Erection of an industrial/commercial unit (Use Class B2) at land adjacent Victoria Spring Business Park, Wormald Street, Millbridge, Liversedge, WF15 6RA

We have reviewed the information submitted with the application and ***we object to the proposal*** and recommend that planning permission is refused. Our detailed comments are as follows.

We have reviewed the following Flood Risk Assessment (FRA) titled 'Flood Risk Assessment and Drainage Strategy (Rev C)', prepared by Advant Engineers, document reference '25048-DOC-001-C' and dated 11th March 2026.

**Proposed Site Plan**  
1 : 500

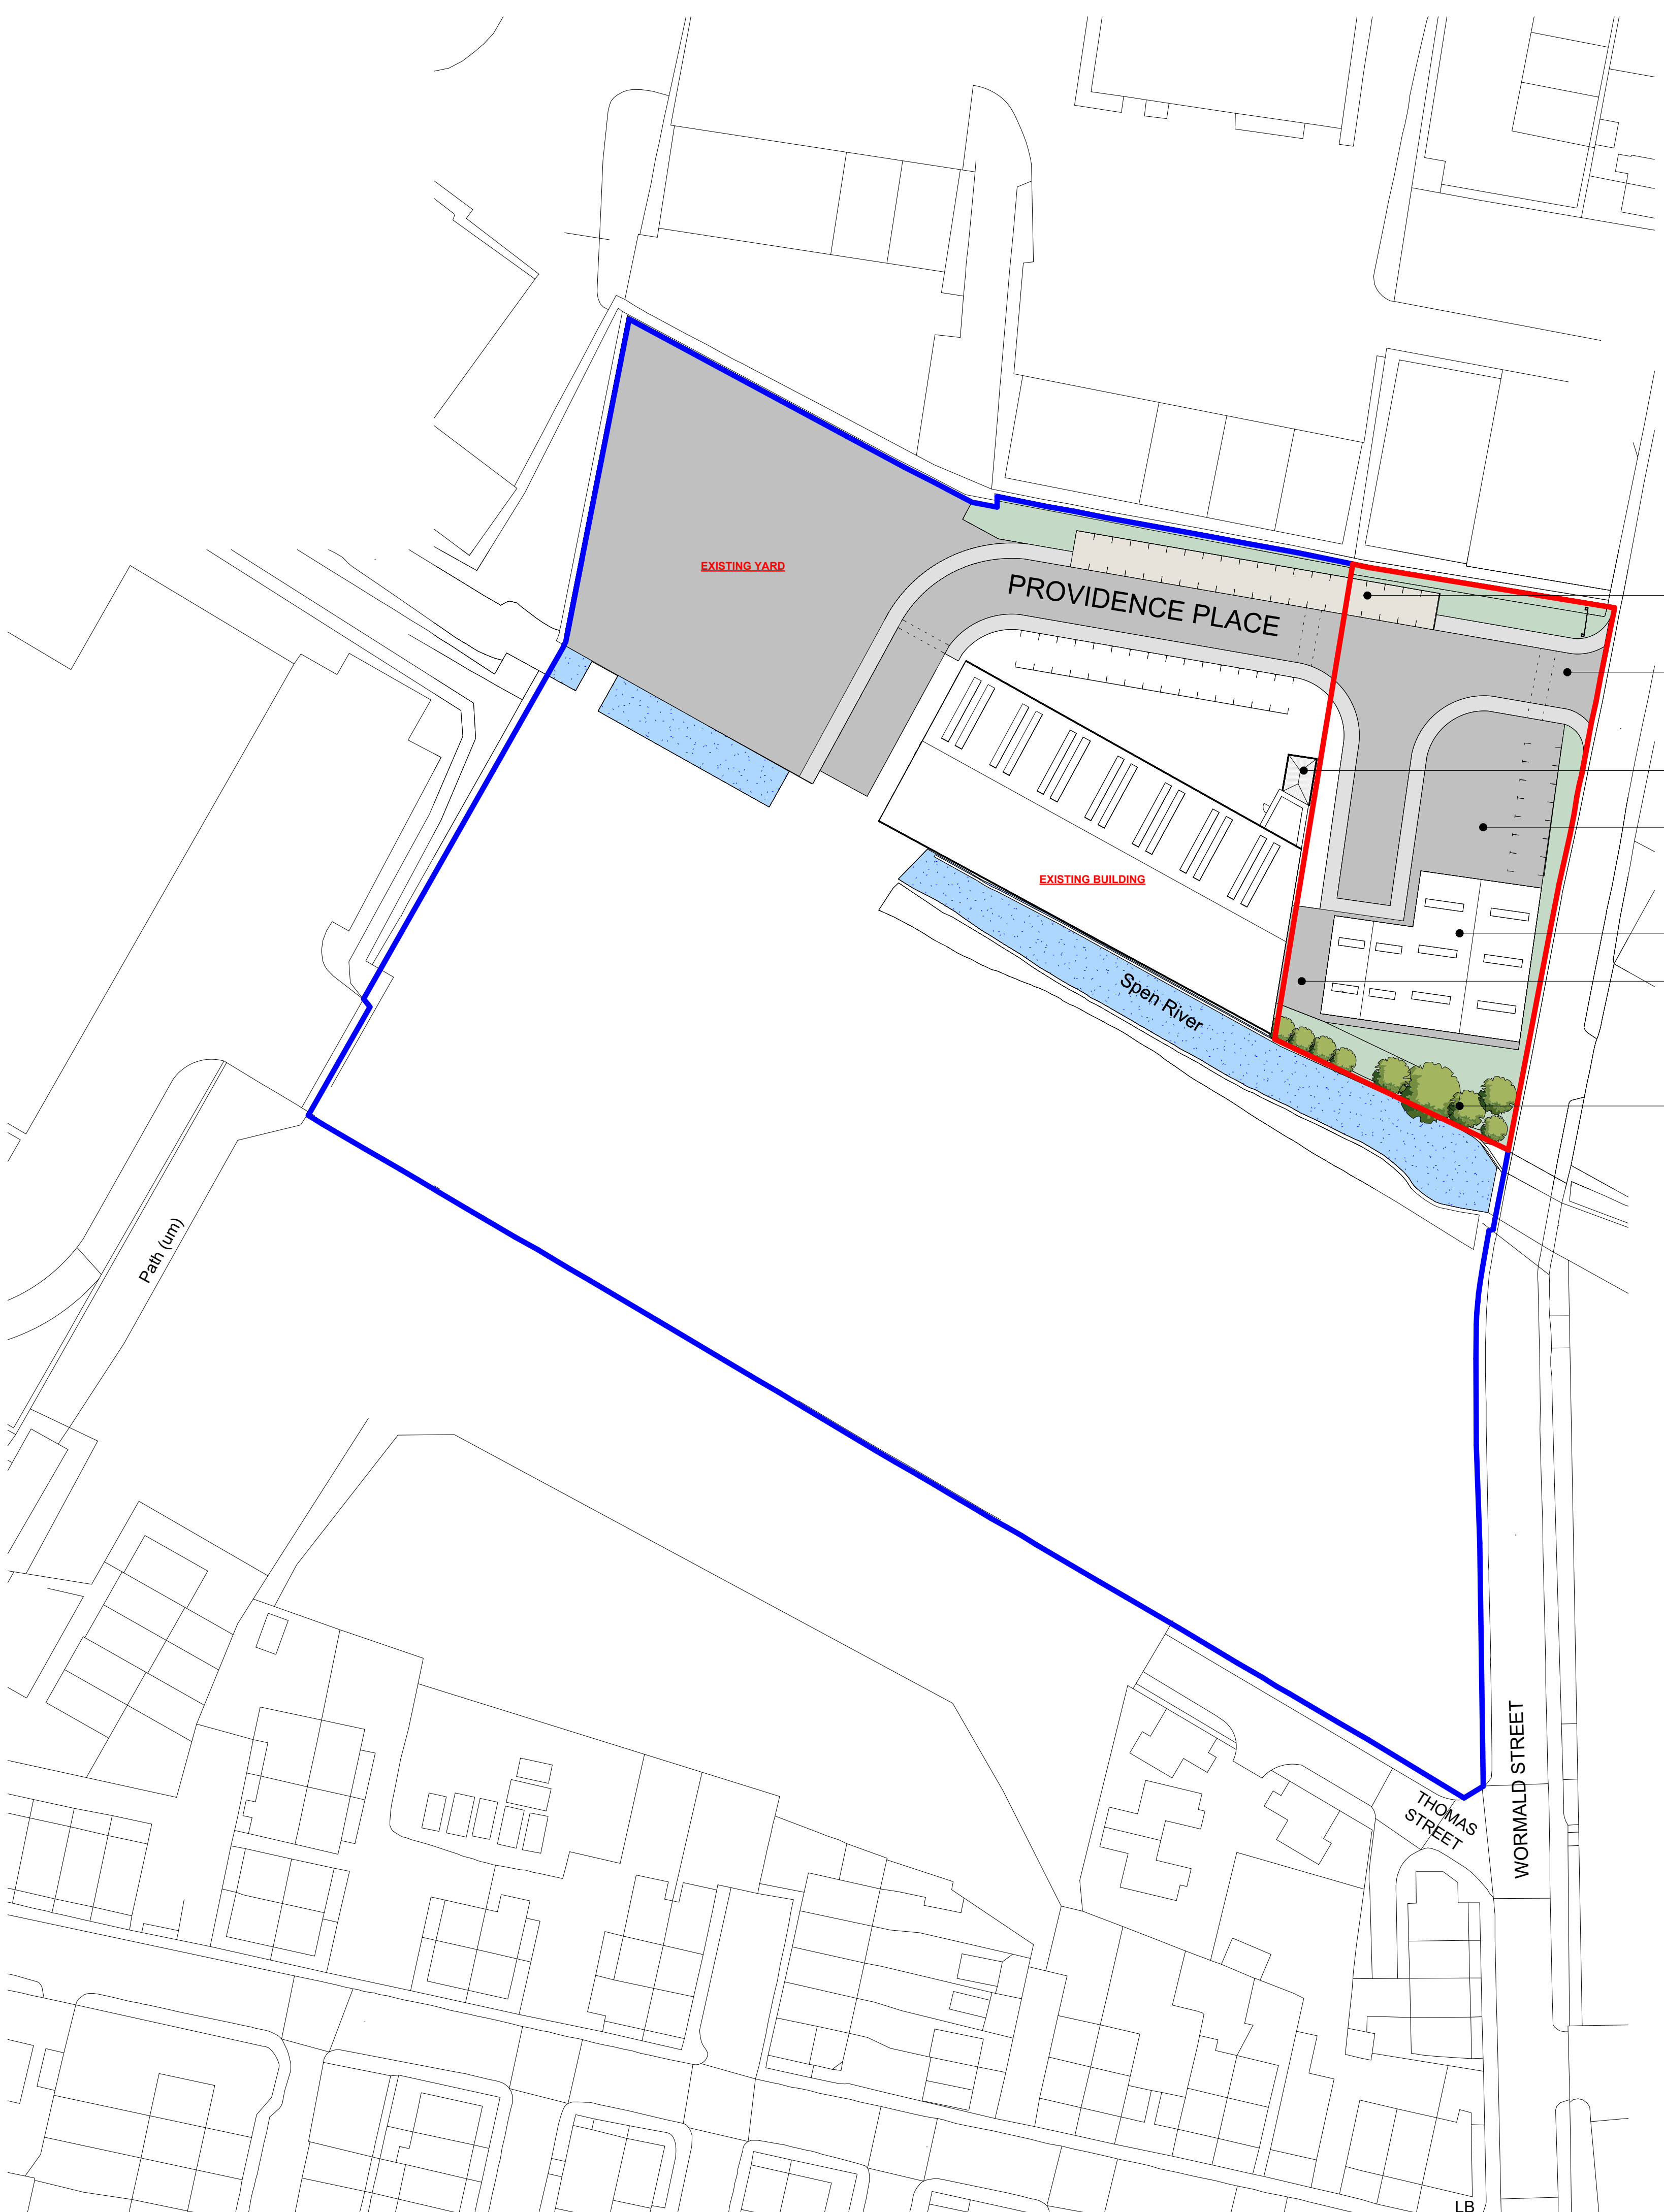
We object to this application as it involves works within 8 metres of a flood defence. As submitted, it is unlikely that we would grant a flood risk activity permit for this application.

The proposed development would restrict maintenance and emergency access to the defences. The permanent retention of a continuous unobstructed area is an essential requirement for future maintenance and/or improvement works.

The proposed development is likely to adversely affect the construction and stability of the flood defence which will compromise its function. The proposed development will therefore increase the risk of flooding to Heckmondwike.

The proposed development should be revised so that there is a minimum distance of 4 metres between the footings of any flood defences and any built development.
